Subject: RE: Request for further information A/138/21/L

Please can you also confirm acceptance of the description: Listed building consent for repositioning of the Golf Clubs main Bar and repositioning of modern timber stud wall to Snooker Room, exposure of fireplace and door opening works and the sealing up of 2 doors (former bar door opening & former door opening into the bar seating area).

J O B	CHECKED
	LRA
Ham Manor Golf Club West Dr Angmering, Littlehampton BN16 4JE	DRAWN
	ES
CLIENT	DATE
	21.06.16
Ham Manor Golf Club	SCALE
	1:1250 @ A1
DRAWING	REVISION
	.
Site / Block Plan	NUMBER
	7133/001

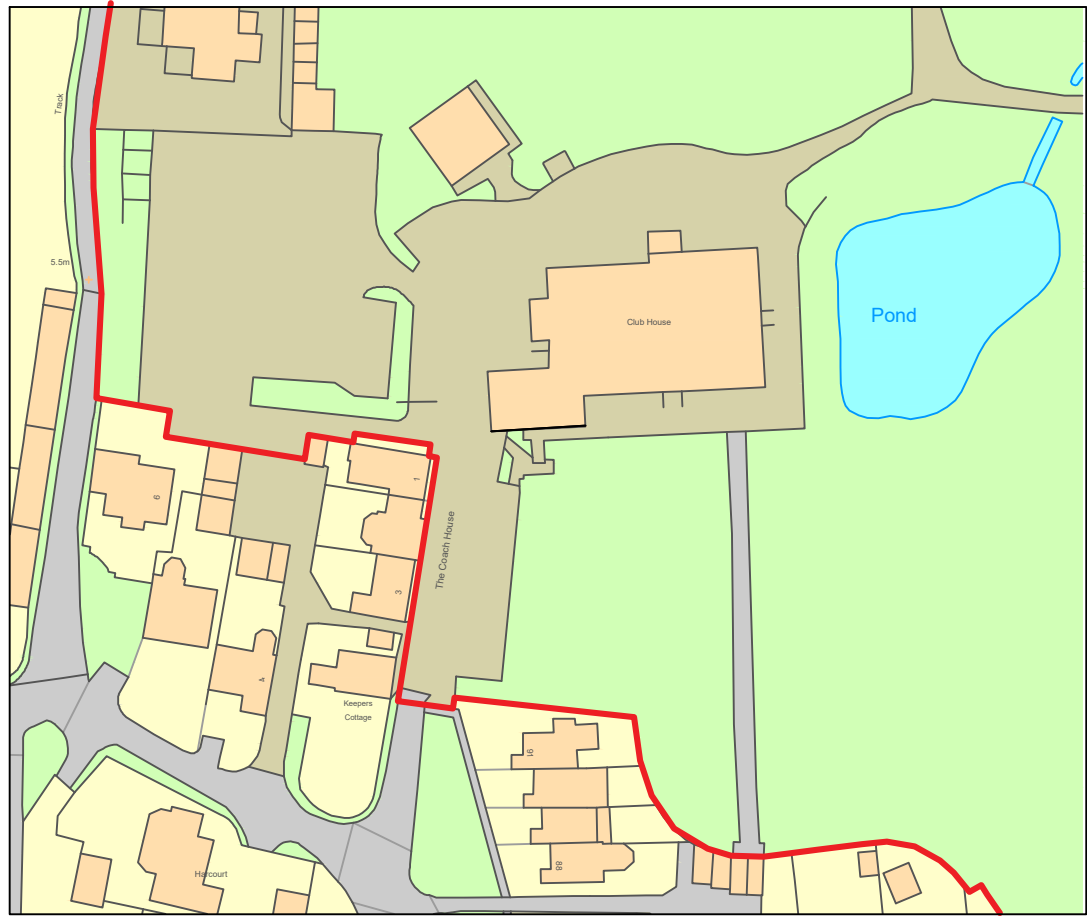
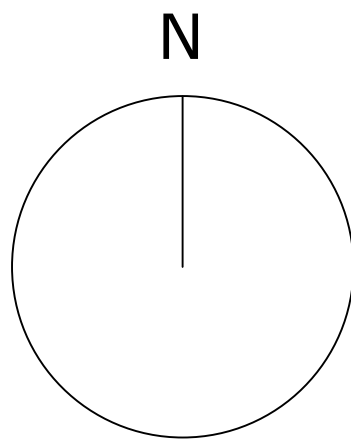
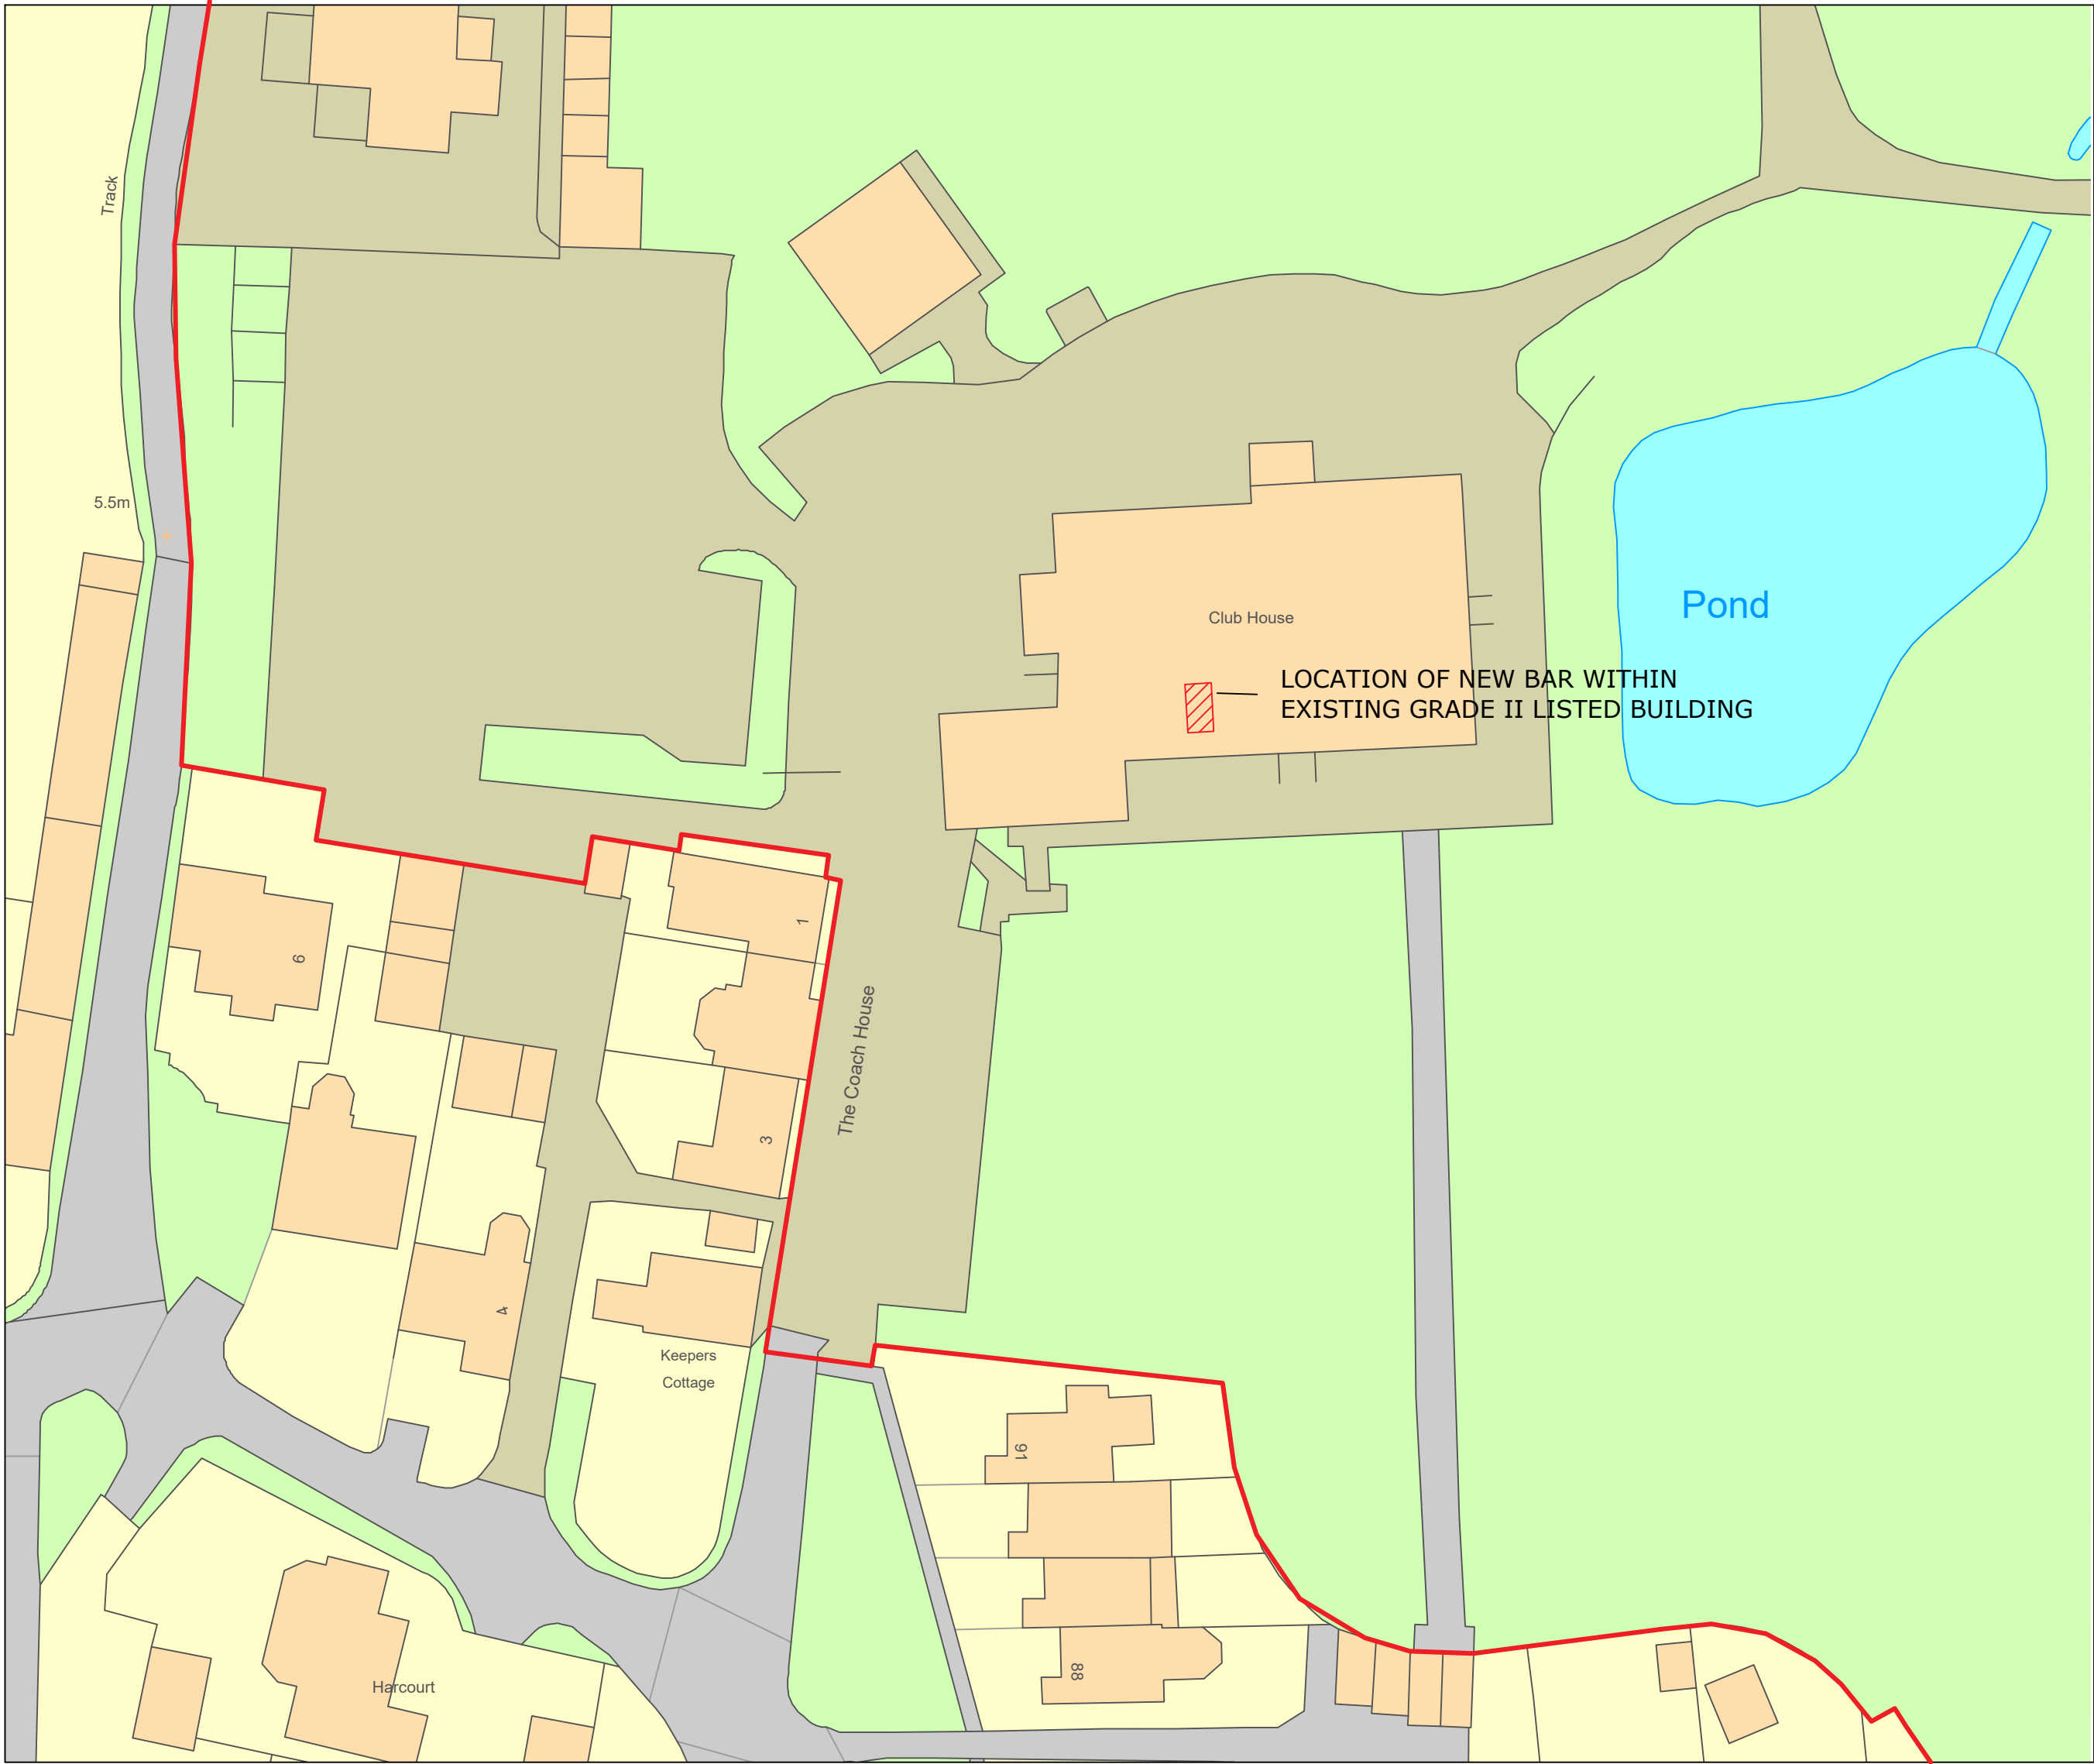
With reference to your email below, it is a Validation requirement that the red edge on the Location Plan shows the whole application site. If you are unable to show the site at 1:2500 you can submit at a different scale in order to show the complete red edge.

The application site is Ham Manor Golf Club which is spread of a very large region of land which if shown at 1:2500 would be greater than a number of AO paper sheets in order to correctly illustrate (in addition to the large cost of purchasing such a big amount of OS Map Data)– as such we instead (as has been accepted as valid before in a number of previous applications to local authorities) shown a greater extent aerial view – which has now been update to show full site ownership boundary in RED.

There is no new proposed external development just some small internal alterations within the Grade II Listed building which require regularisation, in order to be of assistance we have now updated the block plan to show the location of the new bar within the existing Grade II listed club house which we trust is acceptable.
